Item No. **Report of the Head of Planning, Transportation and Regeneration**

Address 40 ROYAL LANE YIEWSLEY

Development: Two storey attached 1-bed dwelling with associated parking and amenity space

LBH Ref Nos: **10789/APP/2019/1414**

PROPOSED REAR ELEVATION

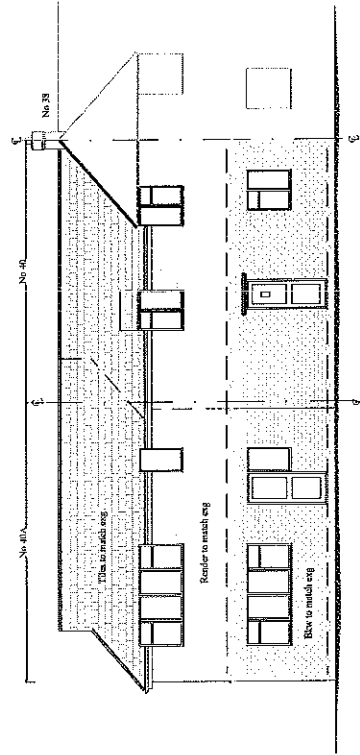
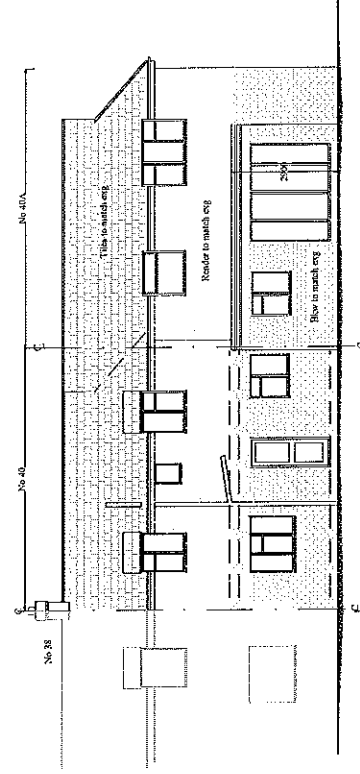
The proposed new dwelling would be sited to the south of and approximately 7m from the nearest rear elevation of the properties in Birch Avenue. In such a relationship, the proposal would result in the loss of sunlight to the rear amenity space of these properties from late morning onwards and given the 7m separation distance, which is considerably less than the minimum acceptable distance of 15m, the proposed dwelling would have an adverse impact upon occupants of Nos. 2A and 2 Birch Avenue by way of a loss of sunlight, outlook and overdominance. As such the proposal is contrary to Policies BE19, BE20 and BE21 of the Hillingdon Local Plan: Part Two - Saved UDP Policies (November 2012).

The proposed attached house on this open prominent corner site would reduce the visual openness and result in the closing of an important gap, characteristic to the area, which currently exists at this road junction, giving rise to a cramped form of development. The proposal would therefore be detrimental to the character and visual amenities of the street scene and the wider area, contrary to Policy BE1 of the Hillingdon Local Plan: Part One - Strategic Policies (November 2012), Policies BE13, BE19 and BE22 of the Hillingdon Local Plan: Part Two - Saved UDP Policies (November 2012) and to the Council's Supplementary Planning Documents HDAS Residential Layouts.).

PROPOSED FIRST FLOOR PLAN

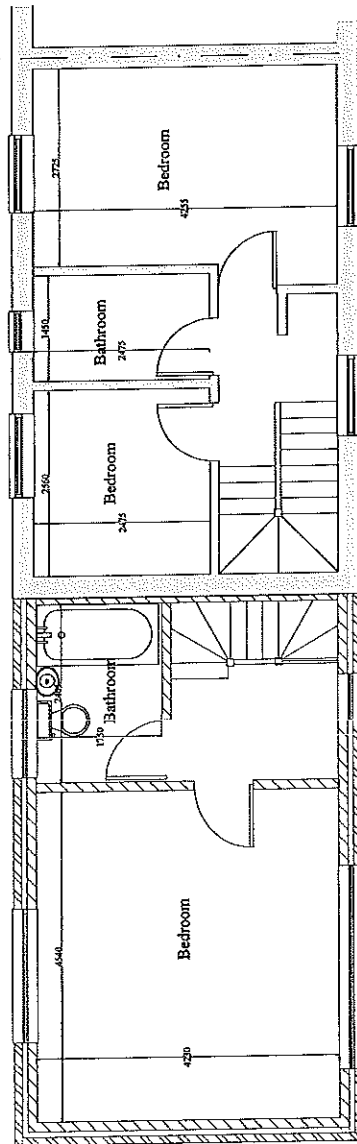
The proposed dwellinghouse, by reason of the siting and position of the proposed first floor rear windows, would result in the direct overlooking of the adjoining properties at 2A, 2, 4 and 6 Birch Avenue causing an unacceptable loss of their privacy. The proposal is therefore contrary to Policies BE19 and BE24 of the Hillingdon Local Plan: Part Two - Saved UDP Policies (November 2012) and the Council's Supplementary Planning Documents HDAS: Residential Layouts and HDAS: Residential Extensions.

There are first floor rear windows, one of which serves a bedroom which would allow the direct overlooking of the rear elevations and rear gardens of Nos. 2A, 2, 4 and 6 within a 21m distance and a 45 degree line of sight. As such, these properties would experience a significant loss of privacy. As such the proposal is contrary to Policies BE19 and BE24 of the Hillingdon Local Plan: Part Two - Saved UDP Policies (November 2012).

PROPOSED SITE PLAN (1/200)

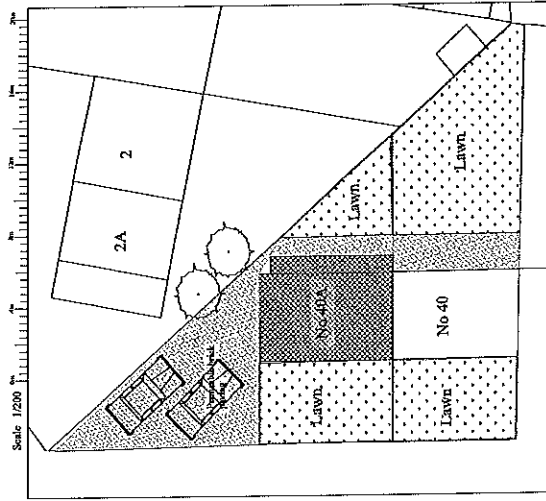
COMMENT: This is a re-submission of application ref. 2018/4145 which was refused. None of the previous tree/landscape issues have been addressed. The existing trees which influence the site have not been acknowledged in the D&AS or indicated on plan.

The total number of proposed parking spaces is 2, one to serve the proposed dwelling and one to serve the host dwelling. The submitted plans do not indicate the provision of any secure cycle storage. The site is located in an area with a PTAL level of 2 which is considered poor and thus the occupants of the existing and new dwellings would rely to a greater extent on private cars.

The proposal would result in the loss of a parking space for the host dwelling and result in a substandard parking provision. As such the proposal has not demonstrated that sufficient off street parking/manoeuvring/access arrangements would be provided, and therefore the development is considered to result in substandard car parking provision to the Council's approved car parking standard, leading to possible on-street parking /queuing to the detriment of public and highway safety and contrary to policy AM14 of the Hillingdon Local Plan - Saved UDP Policies (November 2012).
